Project Special Provisions
(Version 06.5)
Signals and Intelligent Transportation Systems

1. 2006 STANDARD SPECIFICATIONS FOR ROADS & STRUCTURES

The 2006 Standard Specifications are revised as follows:

ENGLISH DETAIL DRAWING FOR
INDUCTIVE DETECTION LOOPS

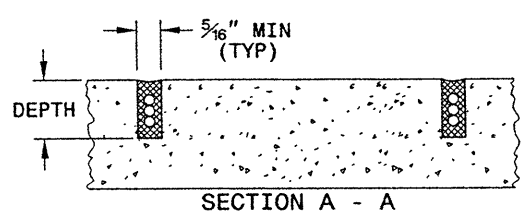
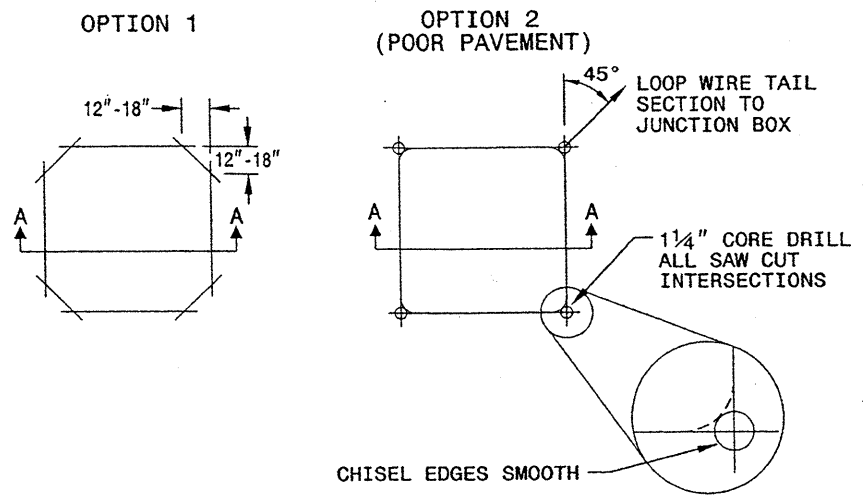
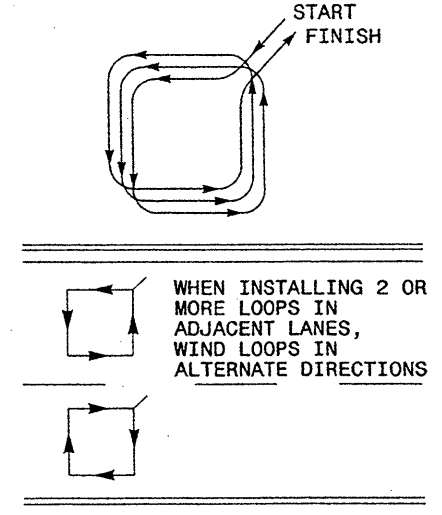
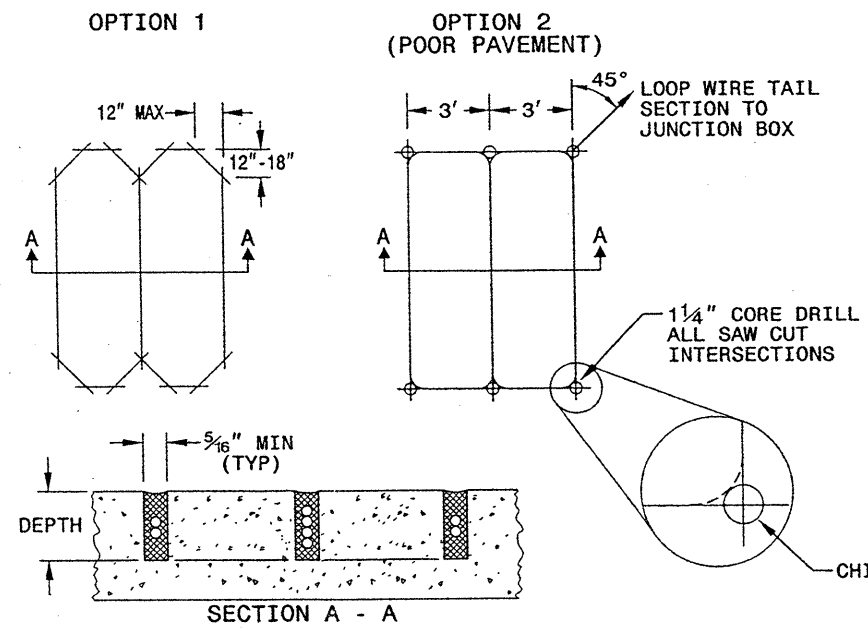
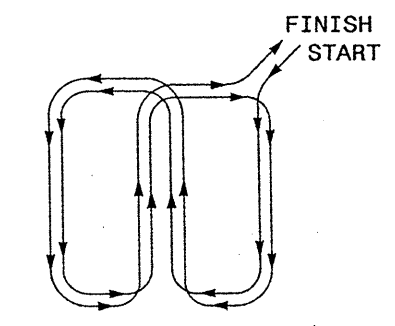
1.4. Inductive Detection Loops – Construction Methods (1725-3)

Page 17-20, Subarticle 1725-3, In the first paragraph on the page, revise the first sentence to:

“Twist loop conductor pairs a minimum of 5 turns per foot from where conductors leave saw slot to junction box.
